Name	Company	Email
To	Michael Azar	Ecove	michael@ecove.com.au
	Charmaine Pang	Bates Smart	cpang@batesmart.com
	Andrew Brohier	McKenzie Group Consulting	abrohier@mckenzie-group.com.au
Date	20/07/2016	Job no SY150512	Version CA1.6
Project	Site 9 – Sydney Olympic Park

1. Introduction

We have prepared this advice to identify and document the fire safety measures that are likely to be required for the proposed residential tower development at Site 9, Sydney Olympic Park to achieve compliance with the performance requirements of the National Construction Code Series 2015 Volume One – Building Code of Australia (BCA)¹. This review is based on the documentation listed in Appendix A.

**General Arrangement Plan  
Ground**

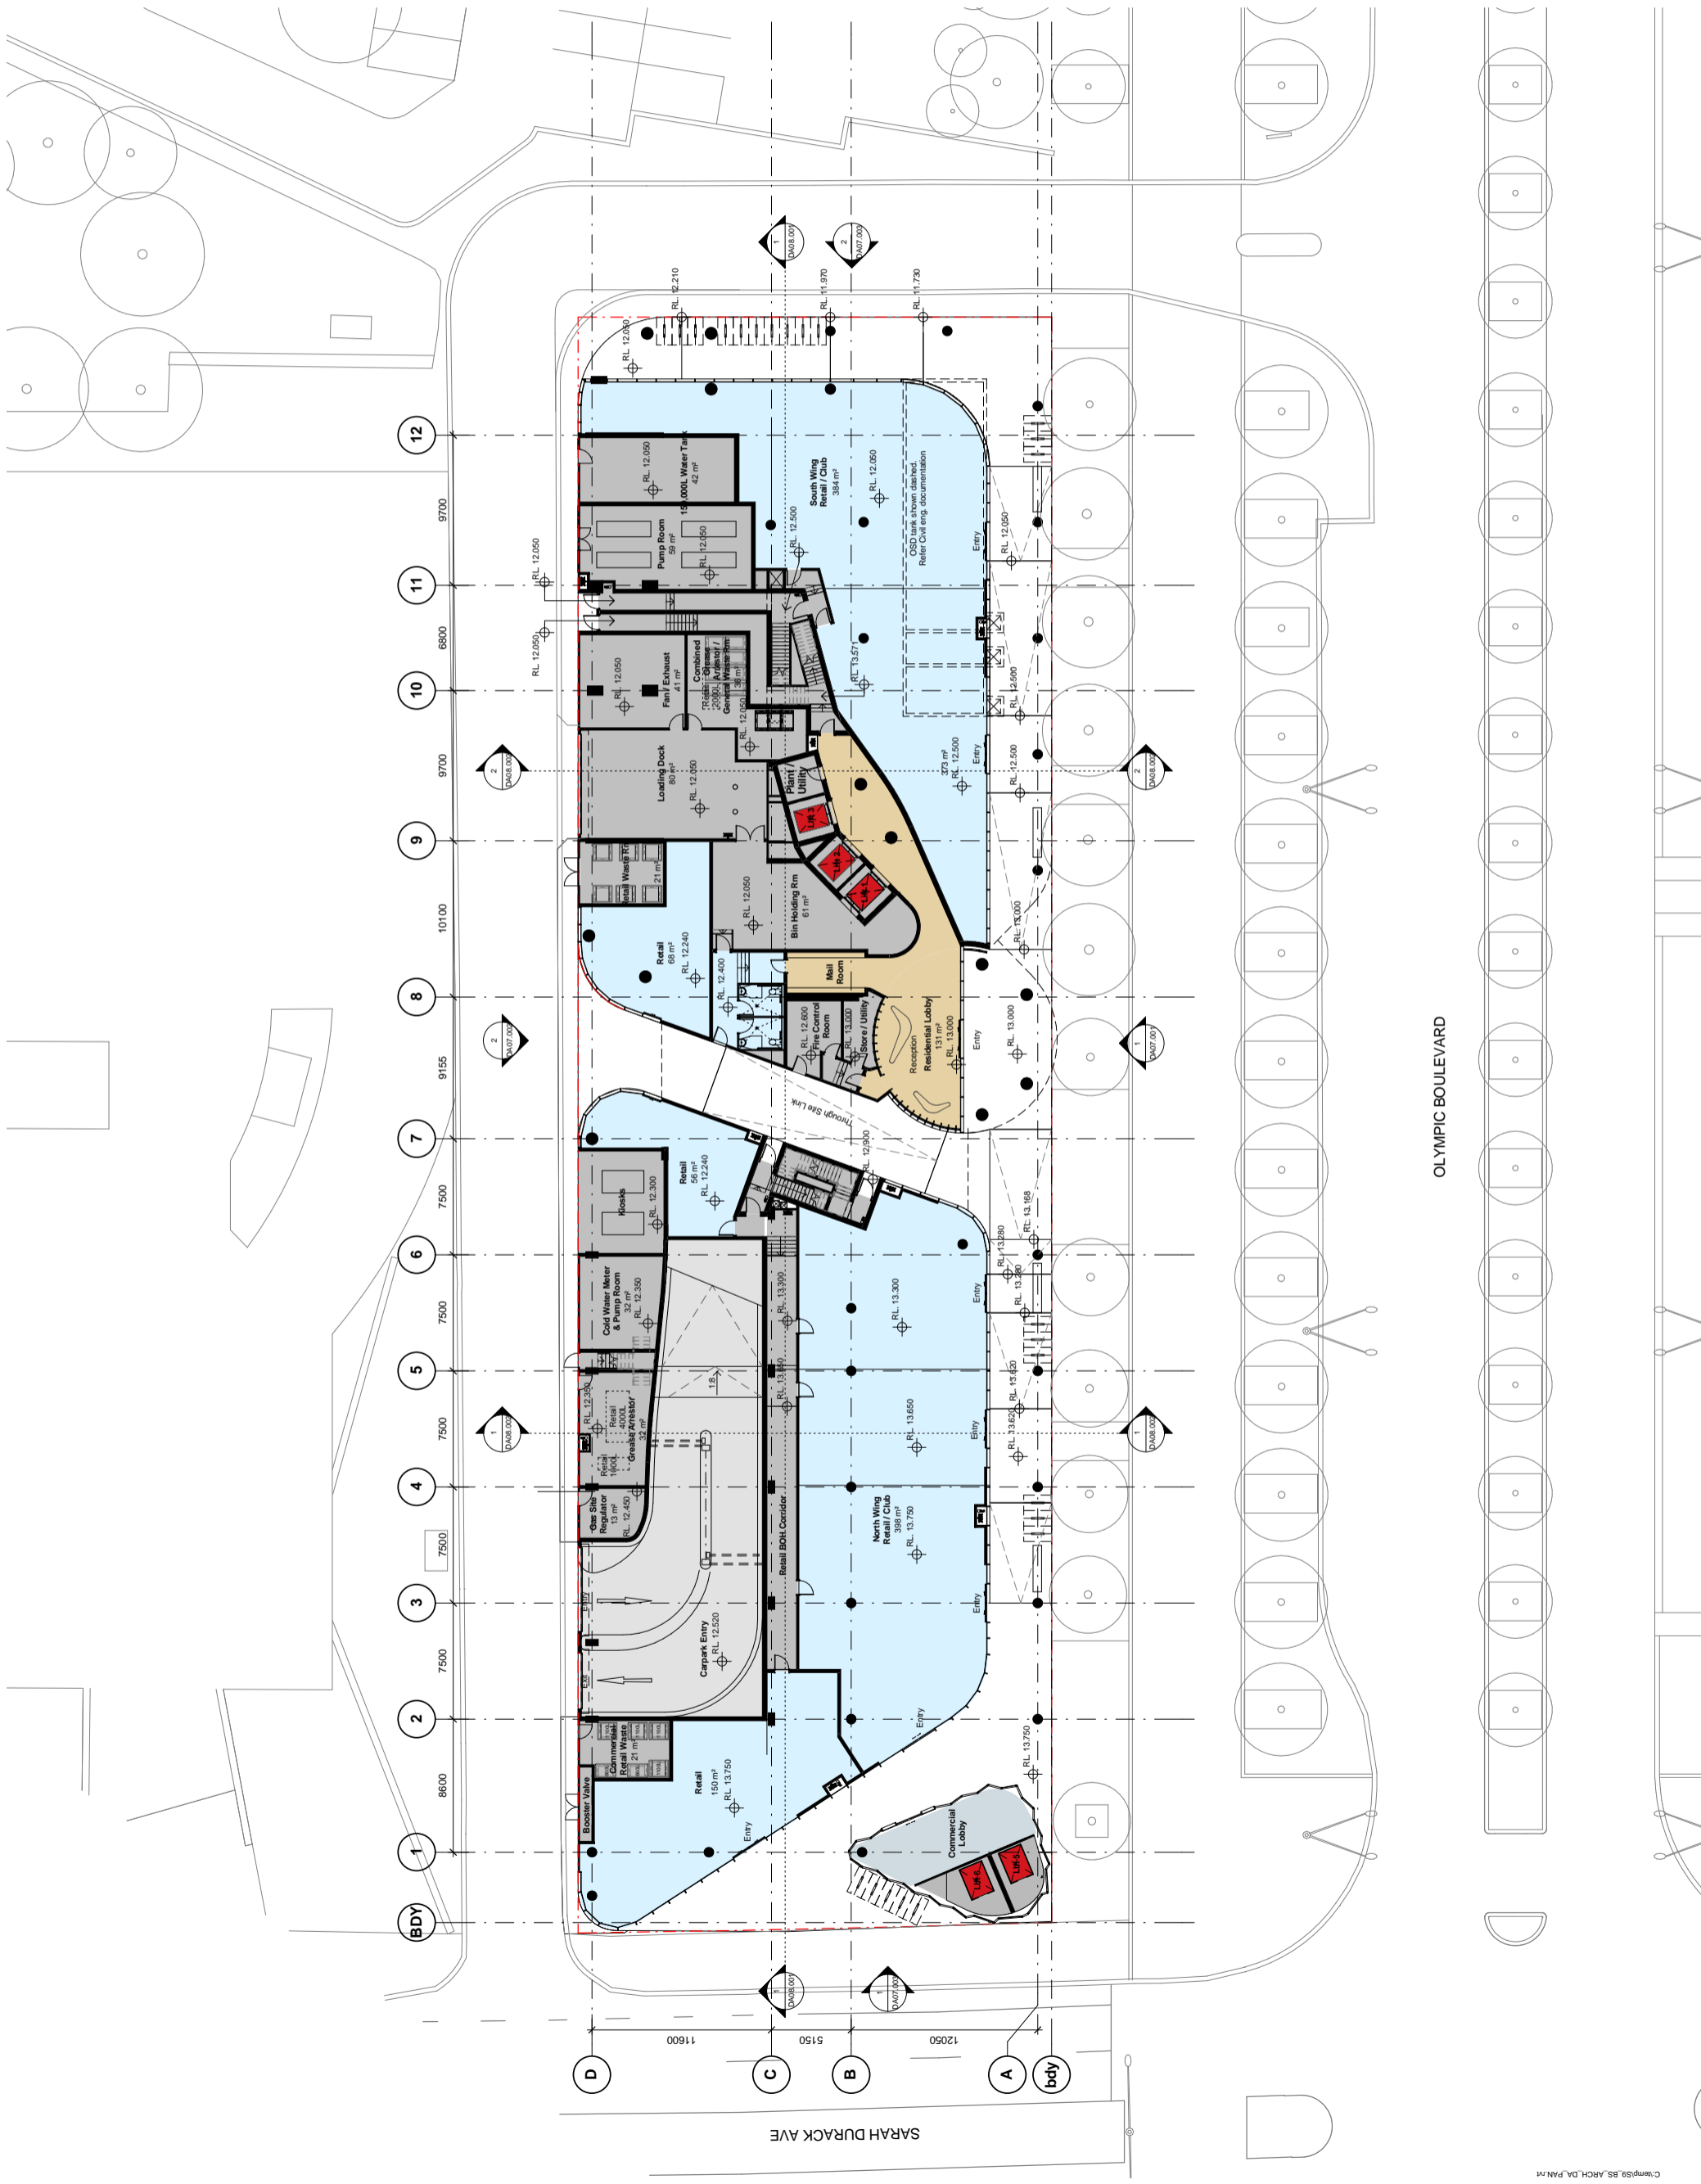
4. The retail areas on the ground floor must be separated from the other classifications on the storey by a fire wall and floor above that achieve an FRL of not less than 120/120/120 instead of 180/180/180 as required by clauses C2.7, C2.8 and C2.9 of the BCA. Refer to **Figure 1**.

18. The proposed location of the fire hydrant booster assembly adjacent to the carpark entry as shown in **Figure 1** is not considered comply with AS 2419.1-2005 as it is not within sight of the main entry to the building being the main residential entry lobby.

**General Arrangement Plan  
Level 07**

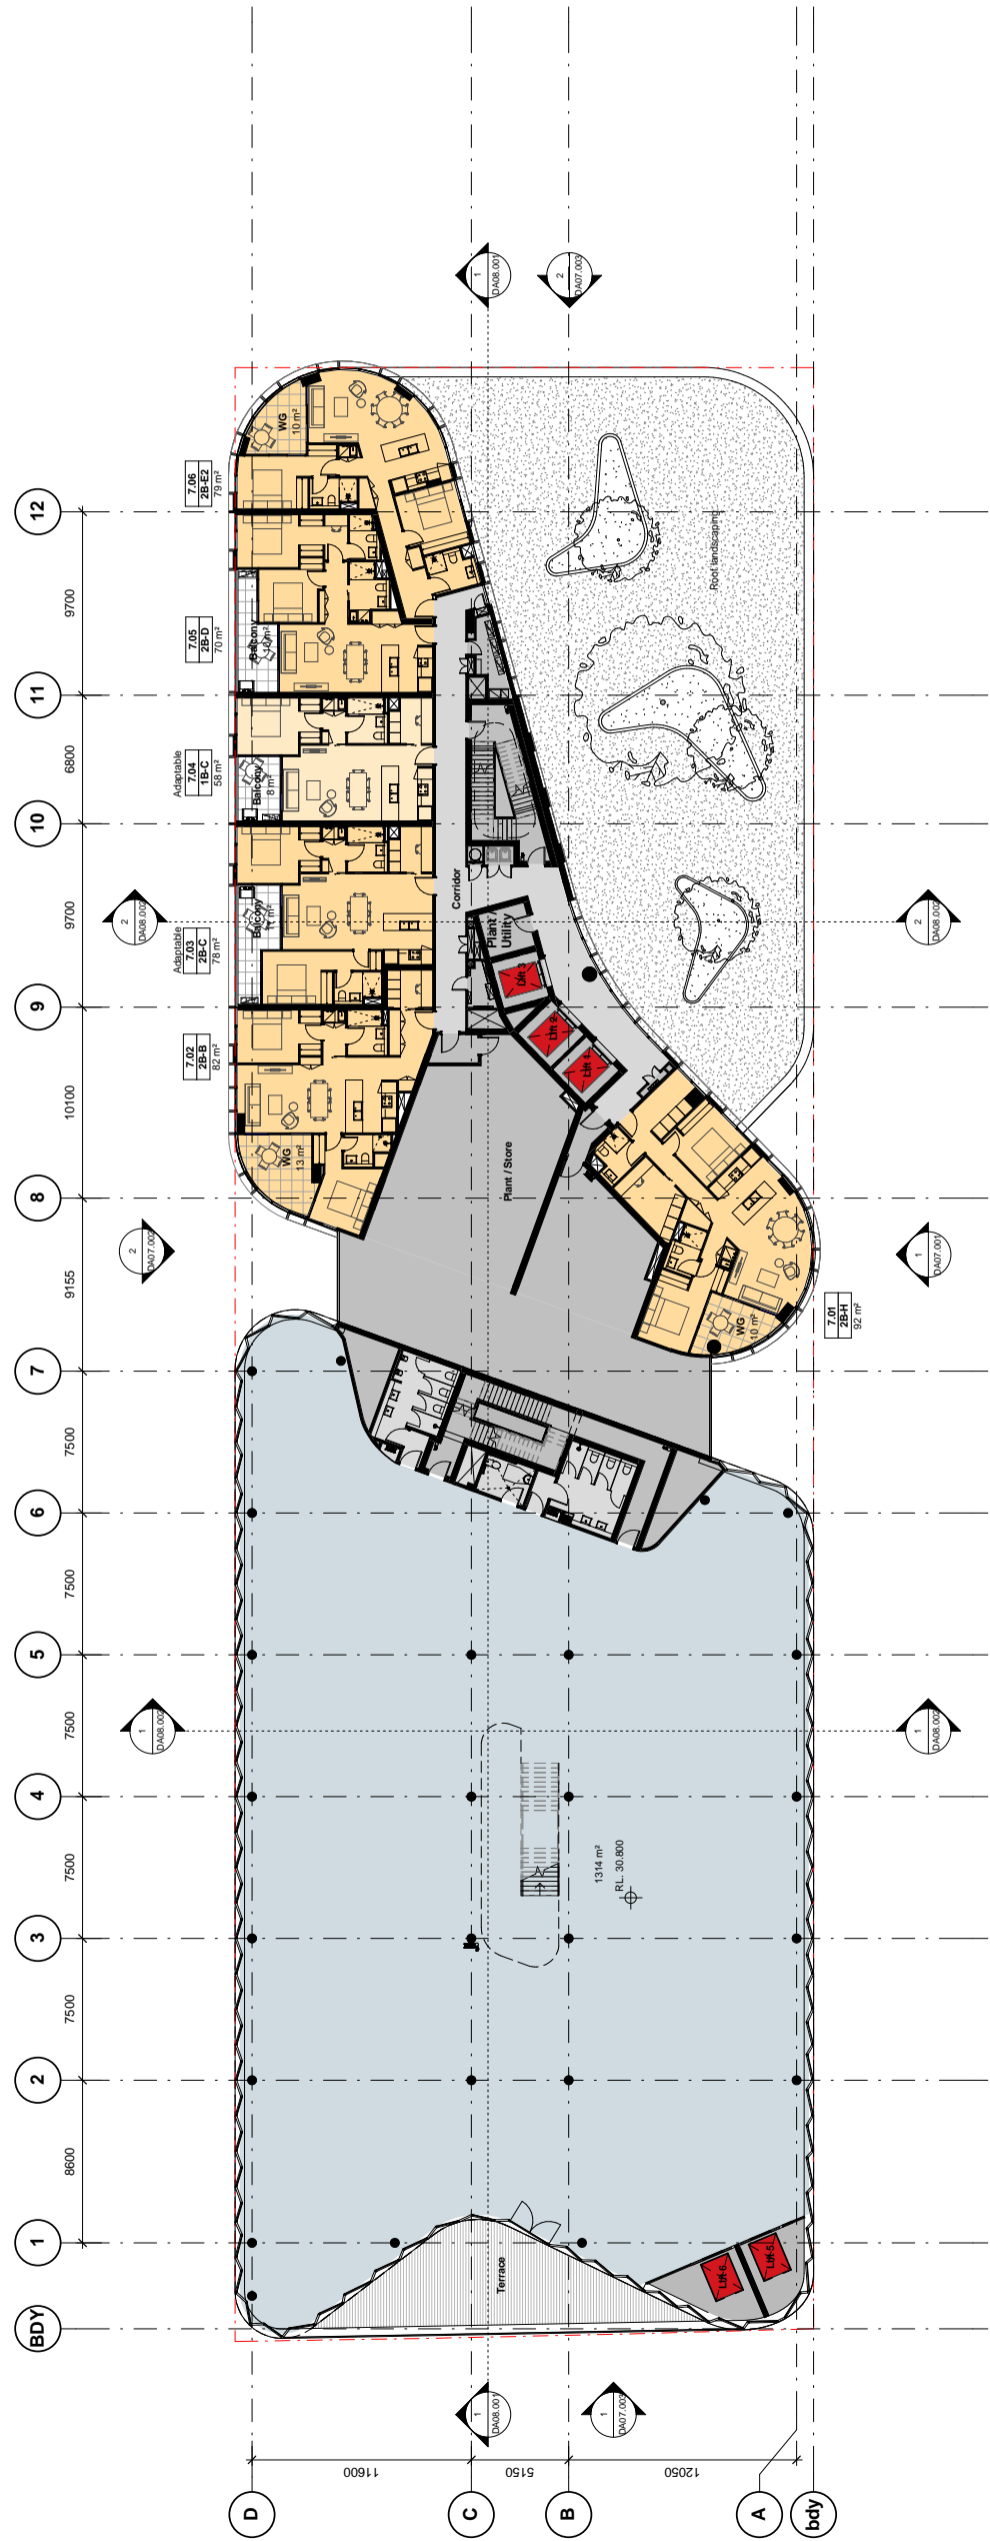
9. The following maximum travel distances apply within the commercial office levels of the building:
- a. 20m to a single exit or point of choice
 - b. 50m to the closest of two or more alternative exits including fitout
 - c. 60m between alternative exits.

11. The maximum travel distance to a point of choice/nearest exit from the plant areas on levels 7 and 8 may be extended to 27m in lieu of 20m.
12. The two entries to the fire-isolated scissor stair serving level 39 of the building may be located 4m apart in lieu of 9m provided a doorway is provided between the plant room and the lift lobby as shown in Figure 7. This doorway is to be protected by a self-closing FRL -/60/30 fire door which may swing inwards into the plant room.
